HPE CM: Raymond Avenue Multi level warehouse Matraville SSD 31552370.

Thursday, 5 May 2022 5:01:43 PM

Given an initial review the following high priority items are raised as issues that Council is of the opinion requires further consideration for this development.

Figure 7: B-Double Approved Route

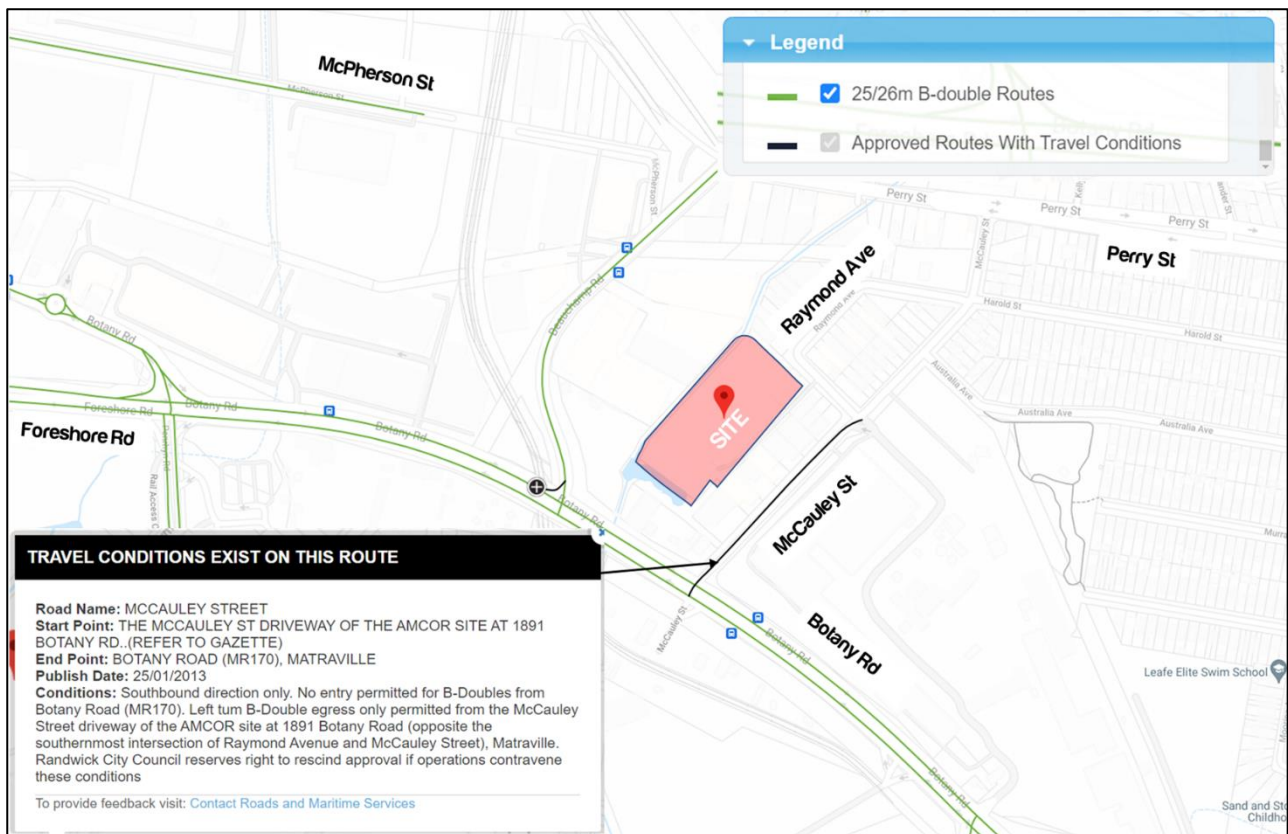
Council notes that there is no reference in the EIS to B double vehicles being required to service the site, However appendix K Transport Assessment notes that Currently access to the Site via Raymond Avenue is not a B-Double approved route. This assessment notes that an application is underway to allow B-Doubles to access the site to and from Botany Road. As Council understands that B doubles vehicles physically cannot use the McCauley Perry Street intersection, approval for this SSD should not be provided until a B double route unless access has first been approved from Botany Road.

Figure 22: Construction Vehicle Routes

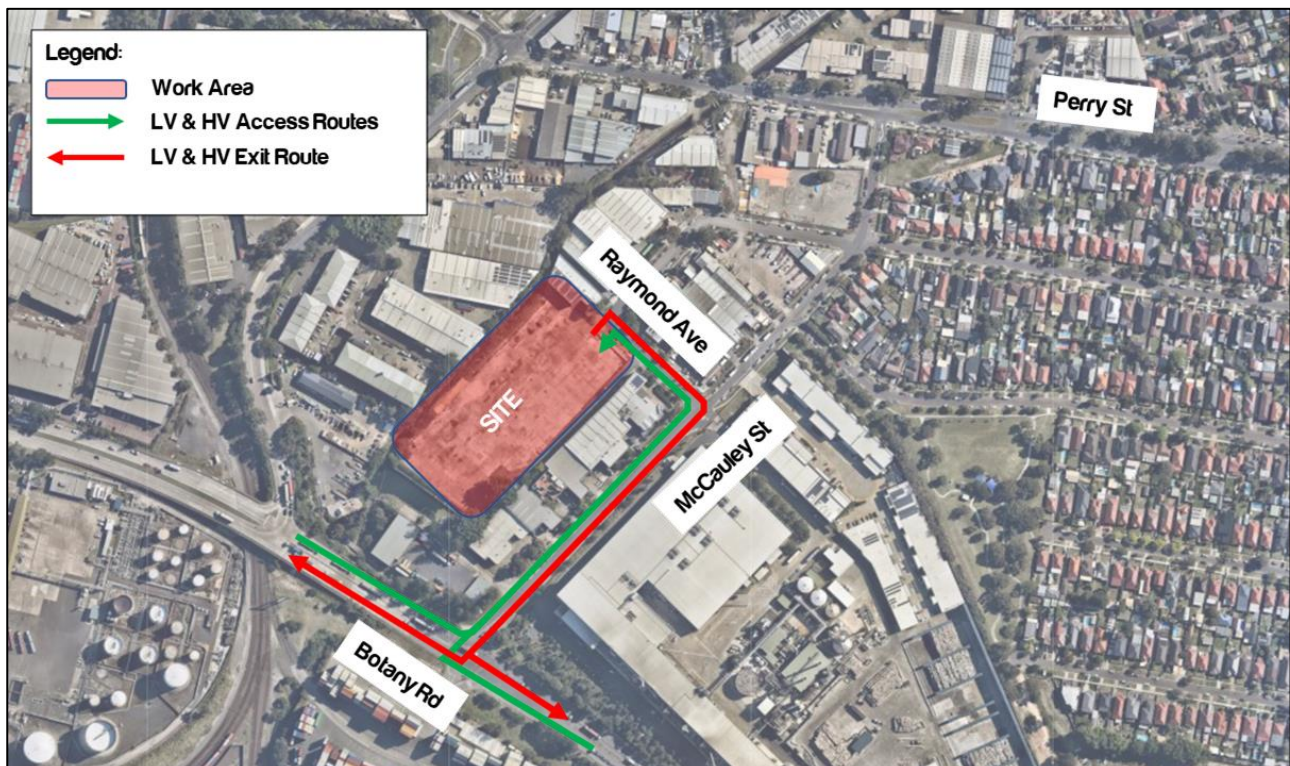
Residents have raised concerns about B double trucks from this proposed development using the Perry Street as Perry St a vehicular weight restriction of 3 tonnes. McCauley St has recently installed an island to prevent trucks over a certain size entering that street. The current traffic conditions of Perry St limiting heavy vehicles from utilising the street need to be preserved to restrict inappropriate use of these residential streets by heavy vehicles.
